EPA comments regarding Enfield Intermodal Logistics Centre – Modification 6 (MP05_0147 MOD 6)

Attachment 1: EPA comments regarding Enfield Intermodal Logistics Centre – Modification 6

DRAFTED BY: JT, AK	DATE: 05/03/2012	PLAN SCALE: AS SHOWN SCALE BAR
PROJECT CODE: ILC-E-G-MOD 6 SITE LAYOUT	DWG NO: SEDP181A

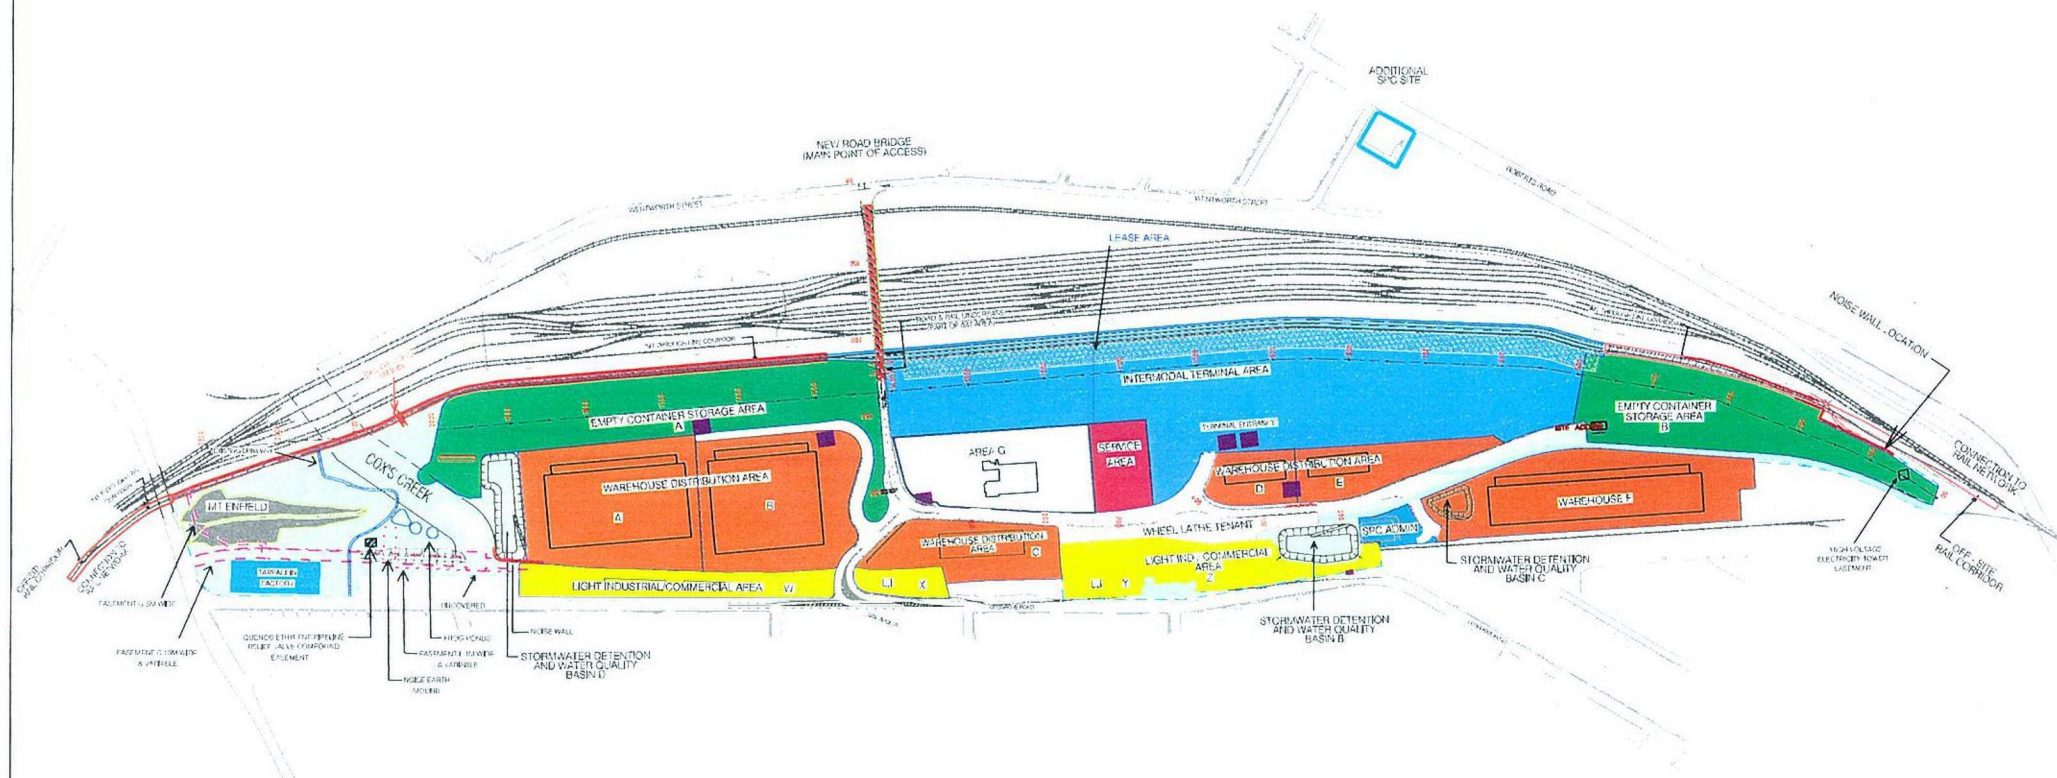
The EPA also notes that the proponent states that container handling will not be undertaken in the area surrounding the high voltage power line tower, but that this area is still included within the 'Empty Container Storage Area B' shown on Figure 3 of the Modification Application documents, and will be included as part of the lease for the Empty Container Storage Area B (page 13). The EPA is therefore concerned that there are currently no measures in place that will ensure that the area surrounding the high voltage tower will not be used for container handling or other noisy activities.

The EPA recommends that if the Project Modification Application is approved, the conditions of approval regarding noise limits remain unchanged. The EPA also recommends that any approval for the proposal also include a condition stating that container handling may not be undertaken in the area that will be affected by the removal of the noise wall. The EPA recommends that this area be marked on a map and referenced in this condition.
